Conservatory to rear & side walls. Porch to front entrance door & realignment of existing boundary wall

44 Merryfield Crescent Angmering

Thank you for your internet comments made on 23rd May 2012 and recorded as follows:

C			
B			
A			
Client	MR. & MRS. WILES		
Address	44 Merryfield Crescent : Angmering		
Drawing	CONSERVATORY, PORCH & WALL	No.	2212:1
Scale	1:50 1:100 1:250	Drawn	B
		Date	APR 12

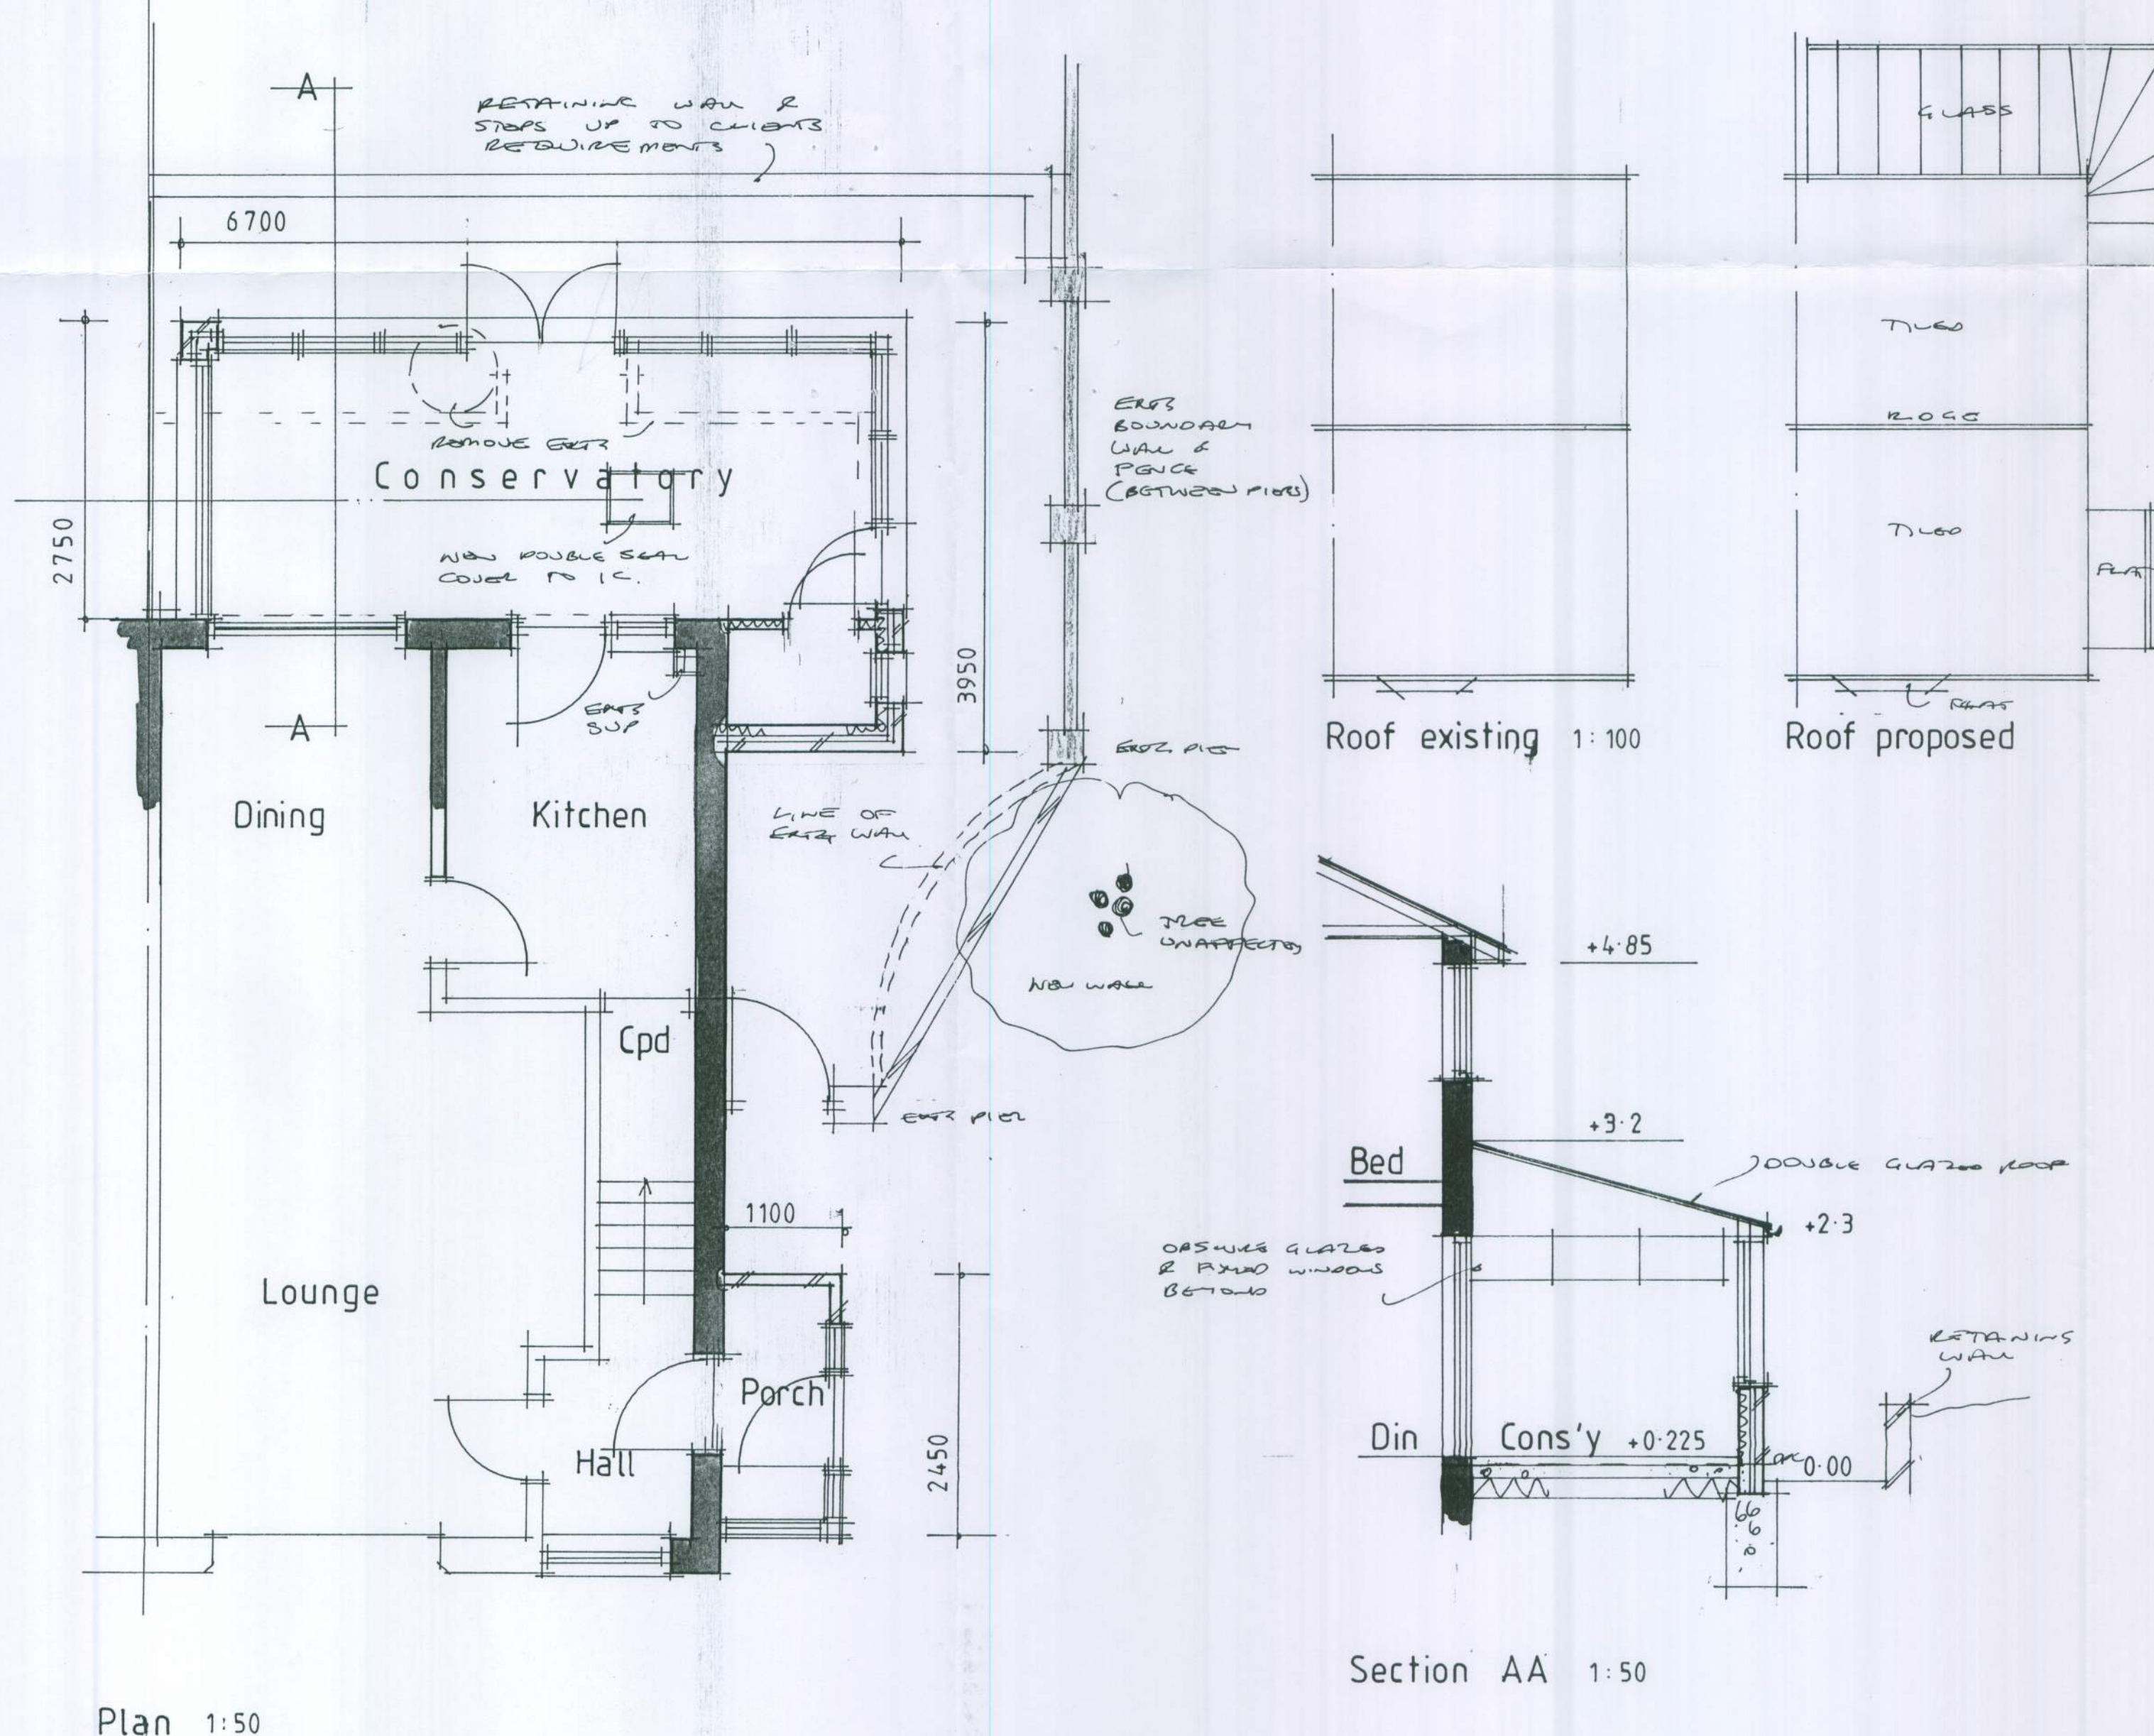
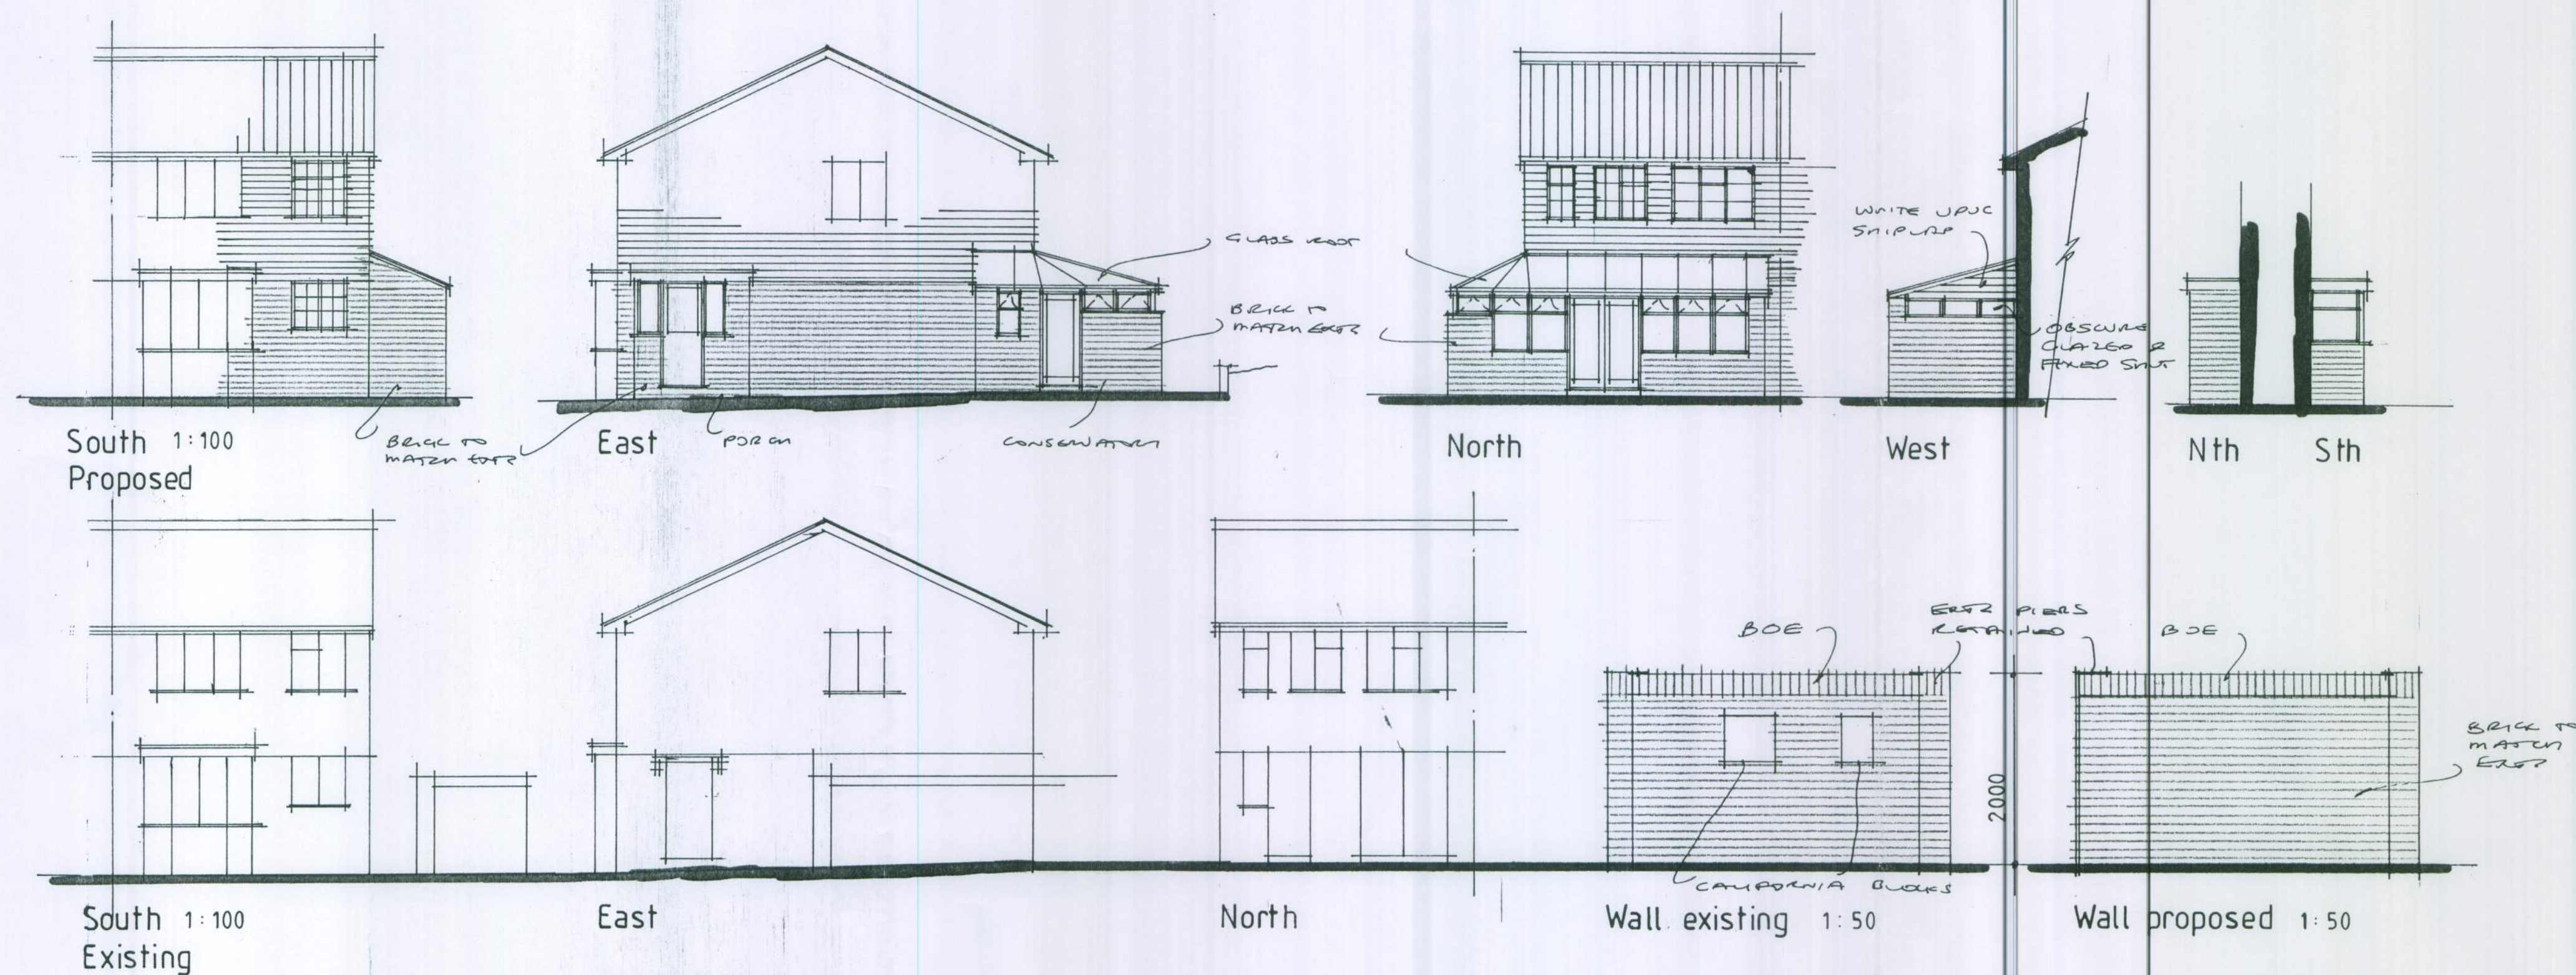
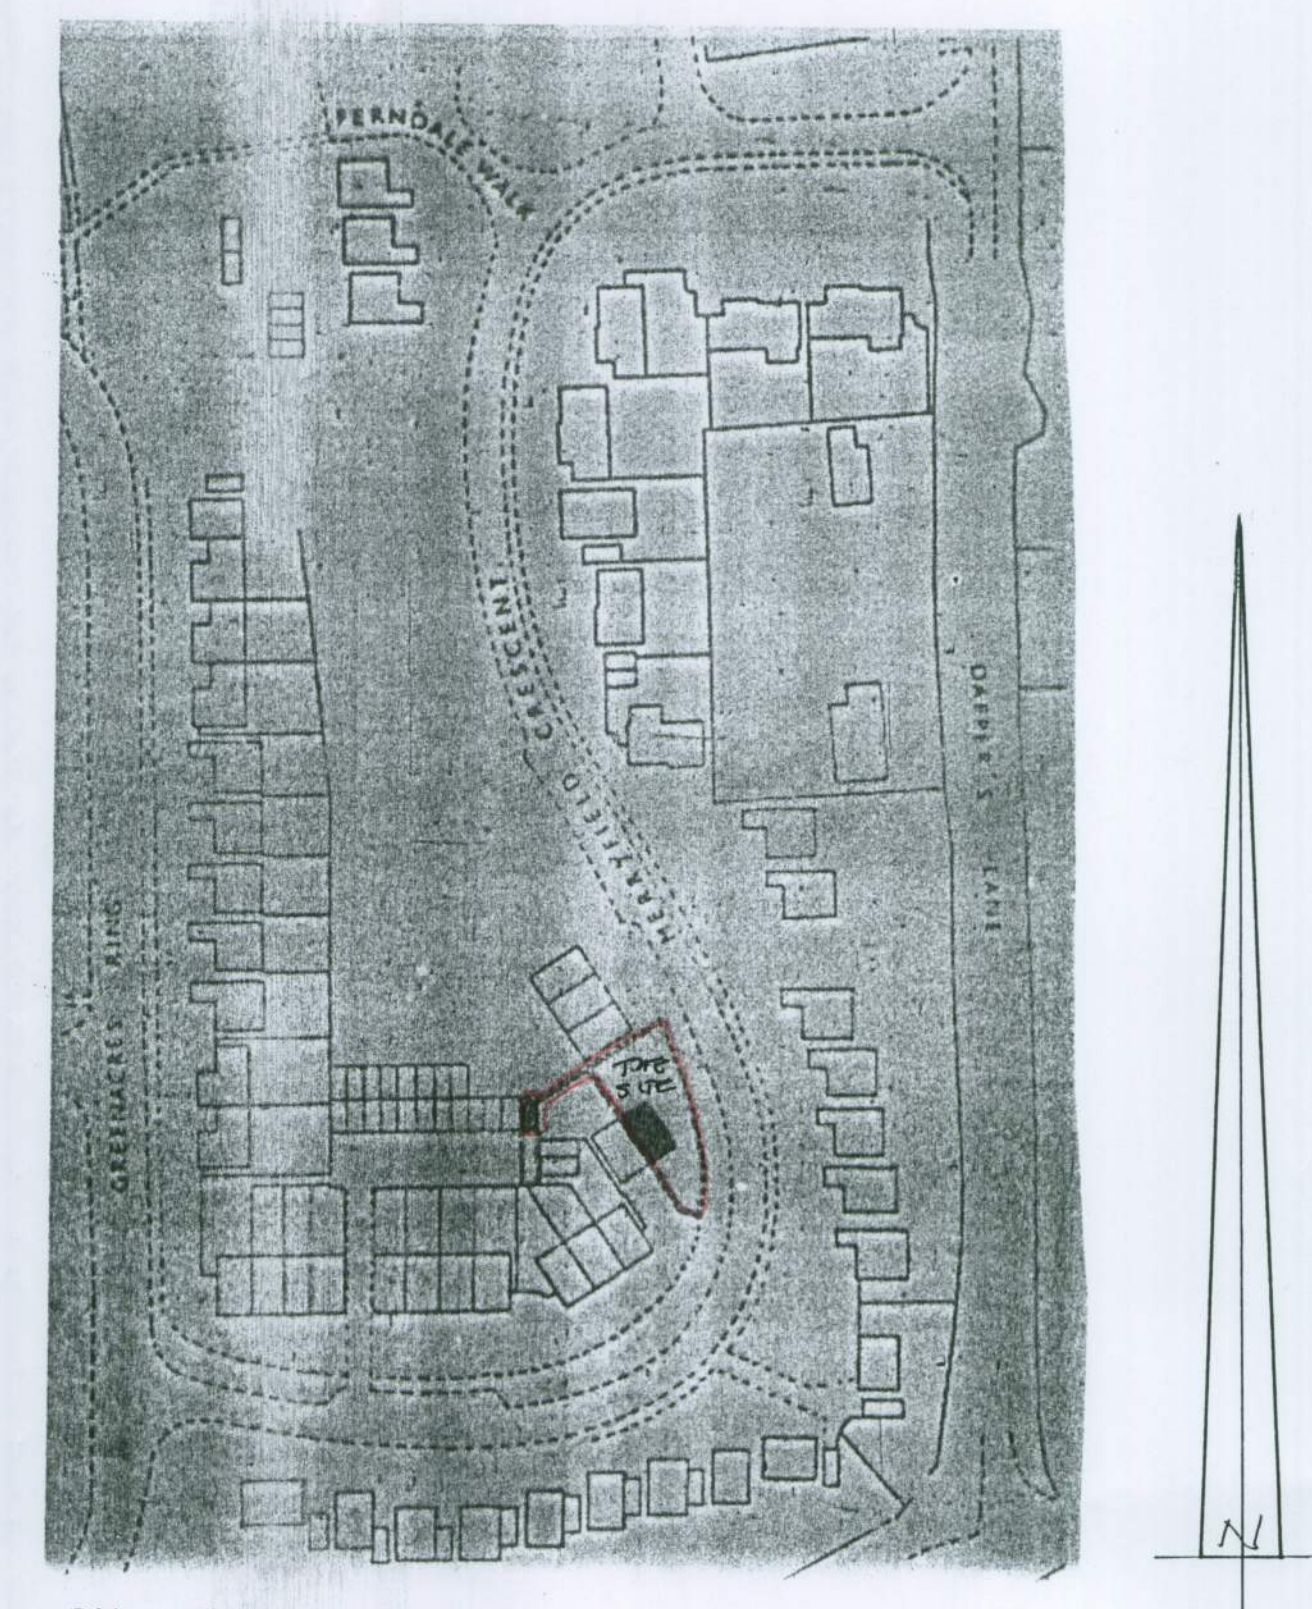
DECISION: No objection to the Conservatory, but objection to the boundary wall being moved as there is no evidence provided that this will not adversely affect the nearby tree.
